REPORT UPDATE

Application No: AL/102/17/RES

REF NO: AL/102/17/RES

PROPOSAL: Application for approval of Reserved Matters for the demolition of existing glasshouses, bungalow, stables & outbuildings & residential development of 268 dwellings incl 30% affordable housing (incorporating 60 senior living units) with associated access, public open space & landscaping

Tree Protection & Removal Plan

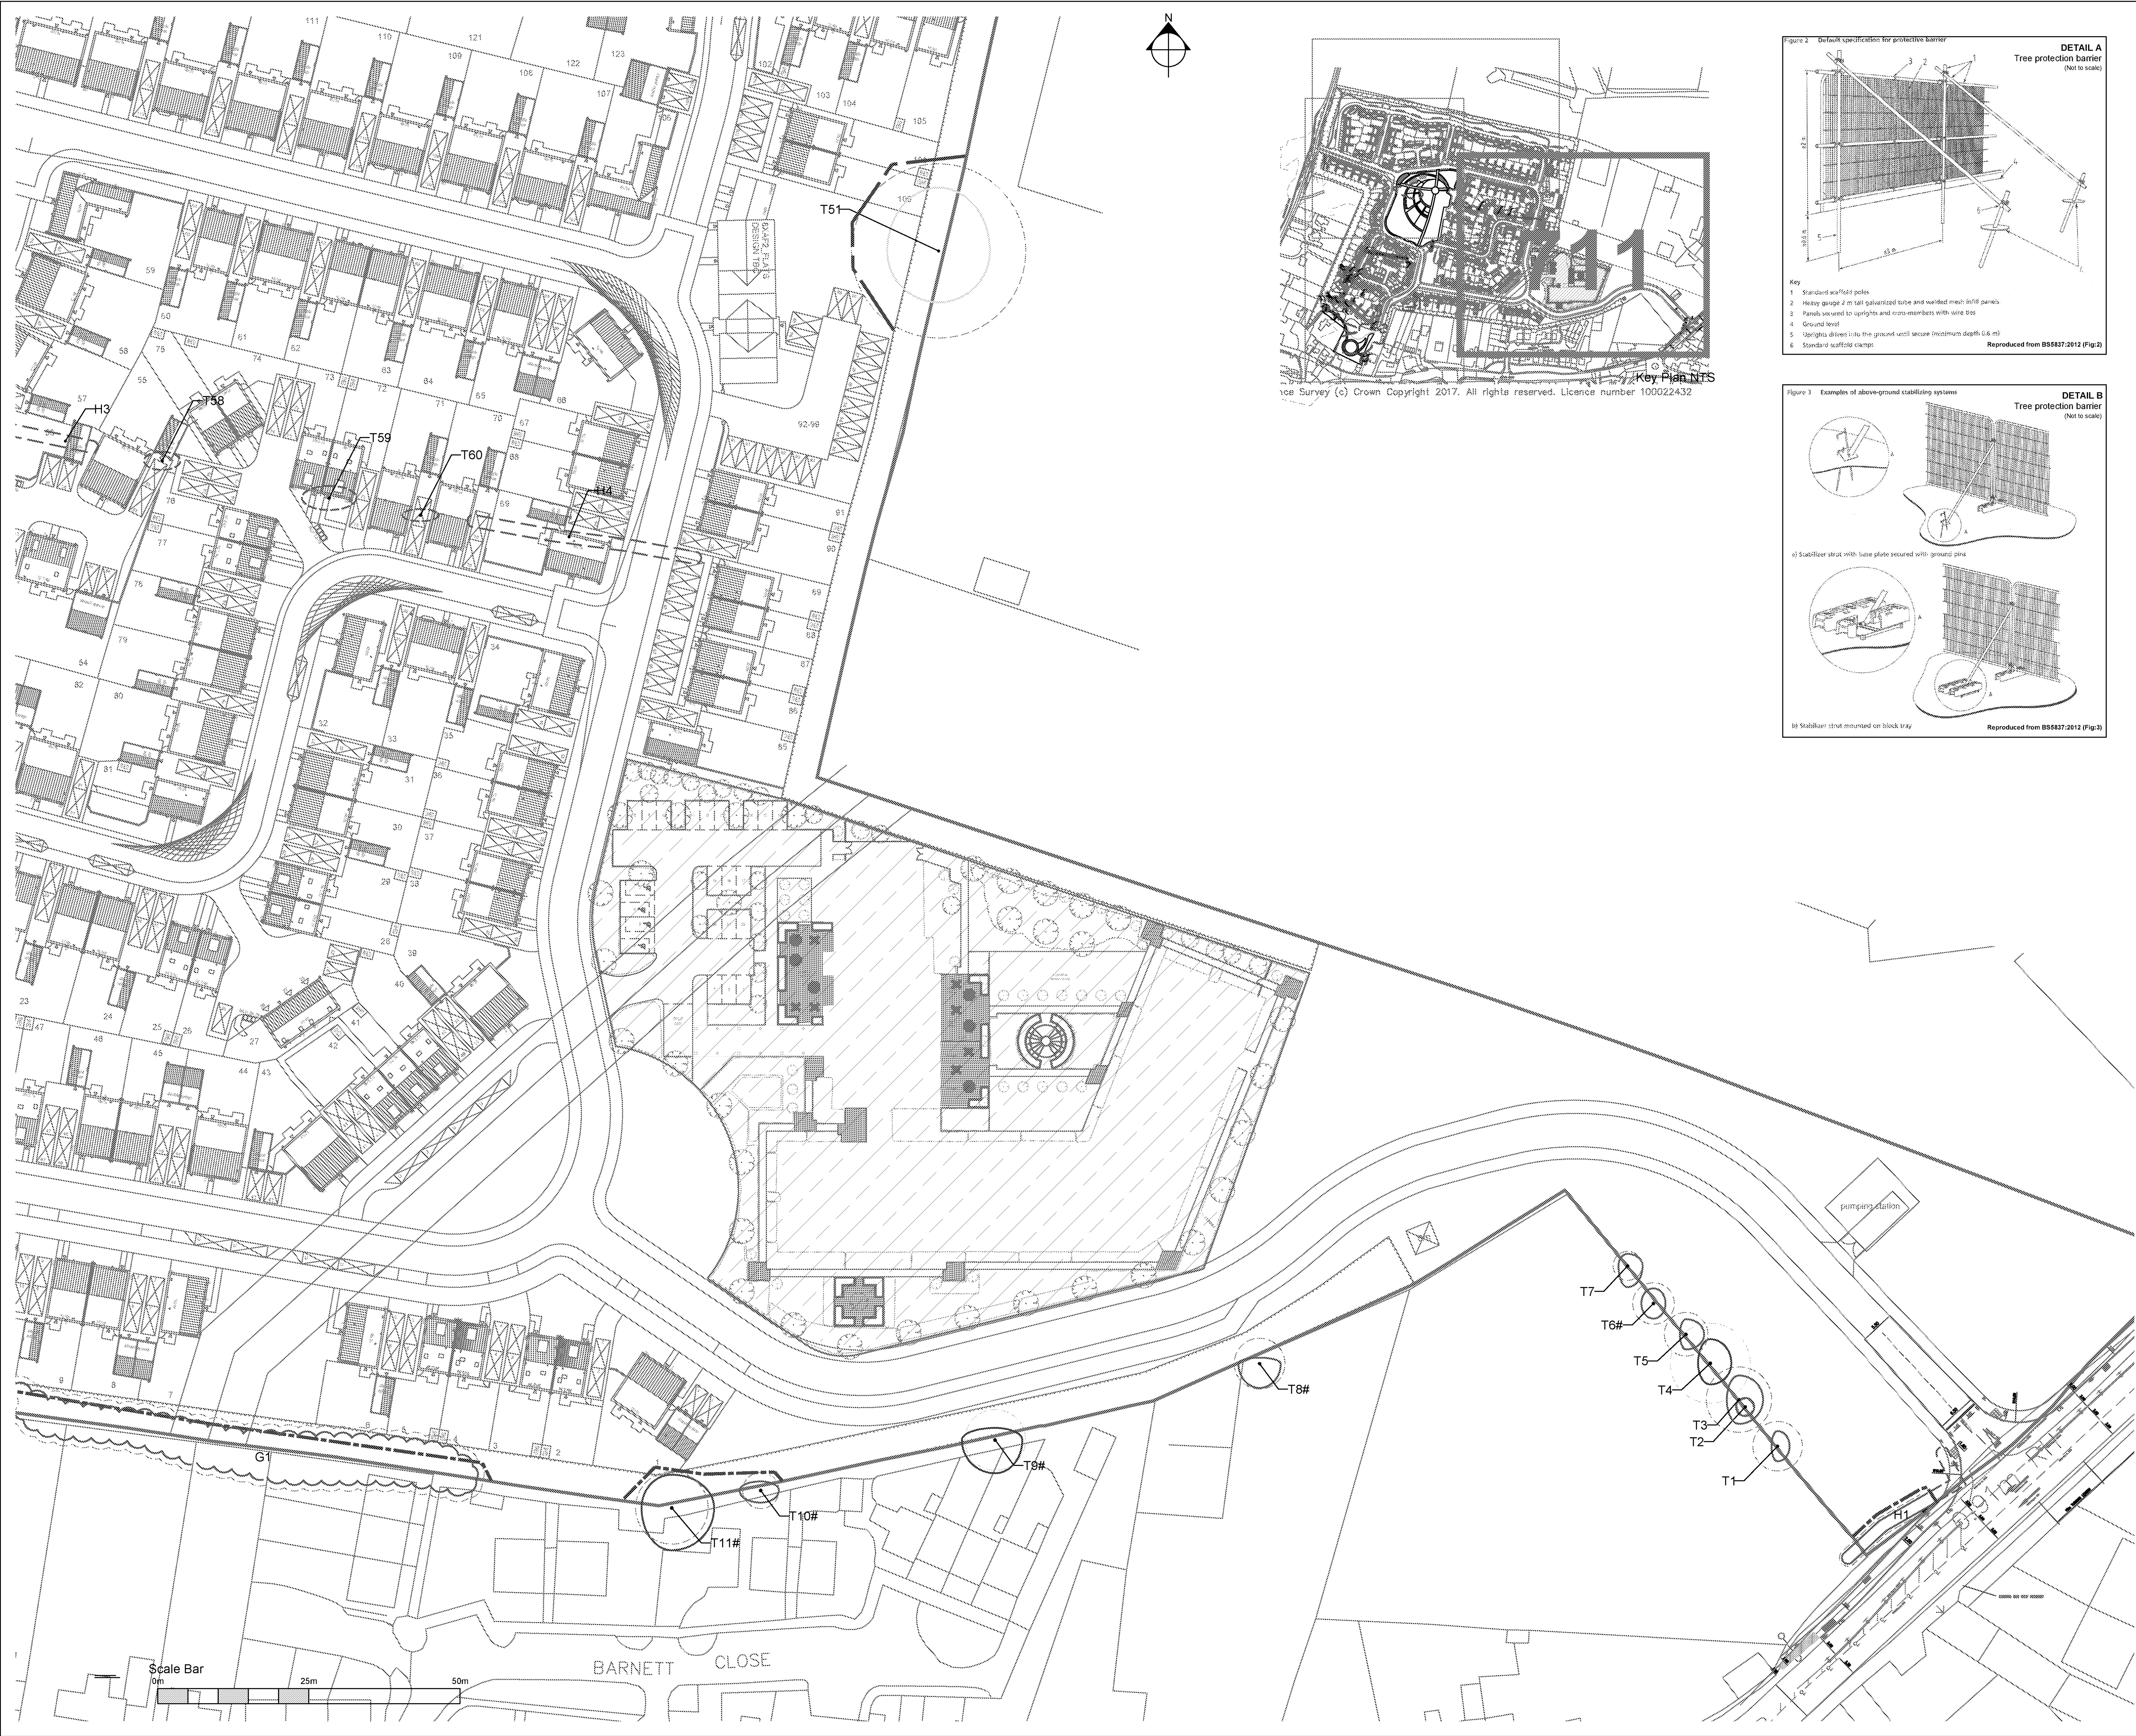
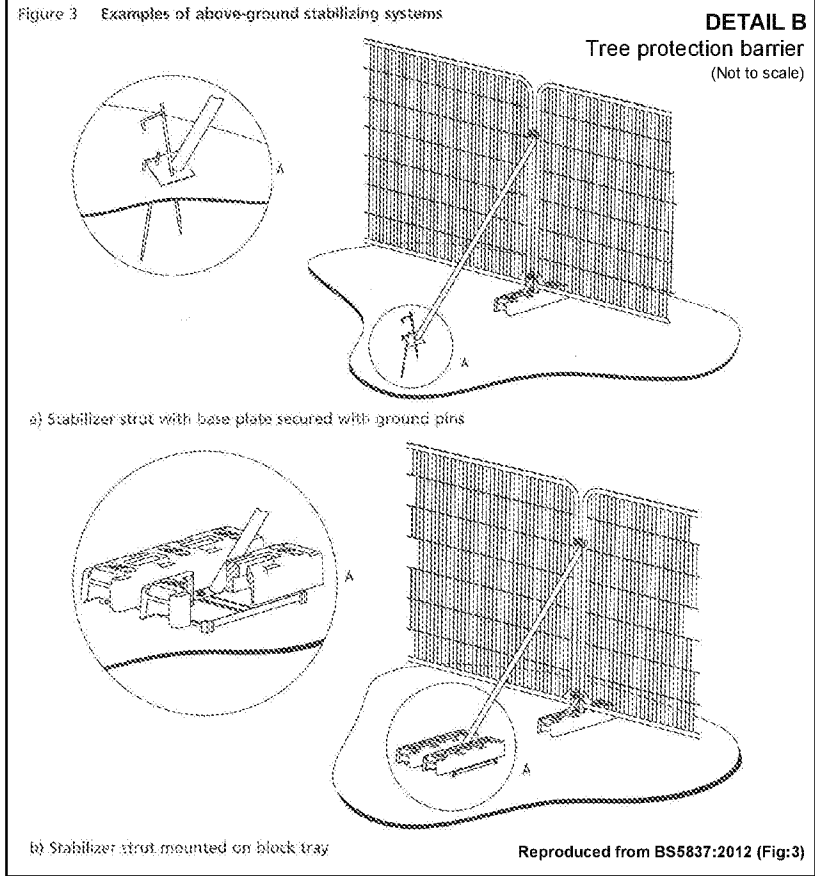
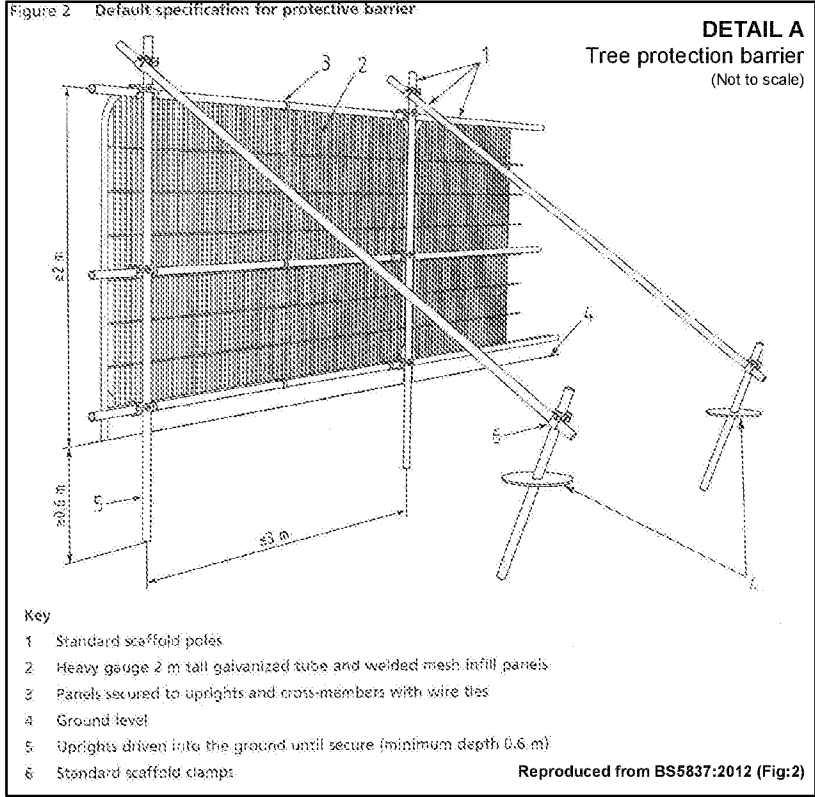
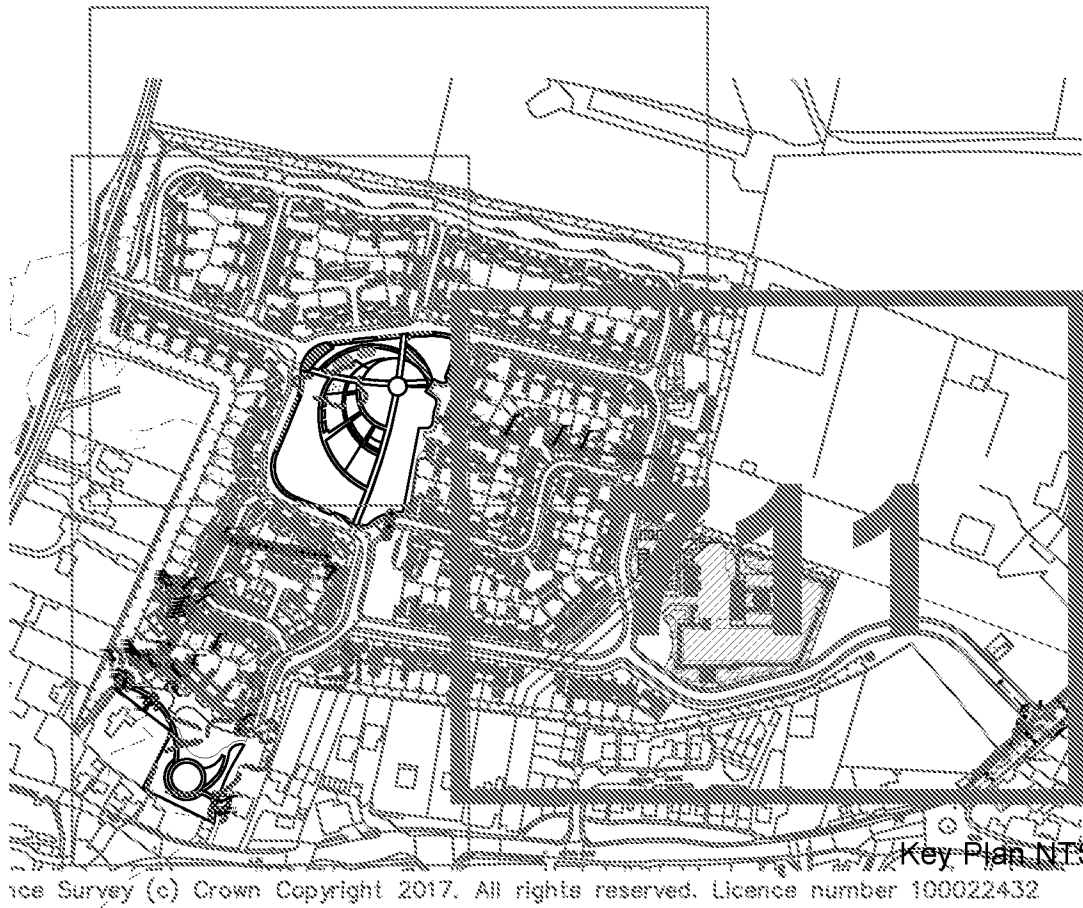
- No issue with trees listed and shown for removal to facilitate this scheme.
- Agree with the appraisal of the TPO'd Holm Oak which requires removal to facilitate the cycle path. It is a young tree of limited value which has growth potential and has already caused significant problems with the associated buildings. Concerns raised in relation to future growth in proximity to building causing problems. Advise that best if allowed to remove the tree and plant several semi-mature Holm Oaks in mitigation as part of open space to north of trees location.

- Unacceptable that two oak trees in centre of open space being hemmed in and placed under pressure from these proposals - re-design should be sought to fully accommodate RPA's of both of the trees with no incursion

A revised layout for the central open space has been submitted which avoids the majority of the root protection area (RPA) for the 2 oak trees. A further comment has been received from the Tree Officer on this layout which considers that it is still not satisfactory due to the large amount of open space available. However, given that the paths now avoid the majority of the root protection areas and the small amount of hard landscaping within the RPA would be constructed using 'no dig' methods, the amendment is considered to be acceptable. The Tree Officer views in relation to the Holm Oak (T15) support the

conclusion in the main report in relation to this tree. Condition 5 of the outline permission will secure the necessary Arboricultural Method Statement to ensure that the correct methods are used.
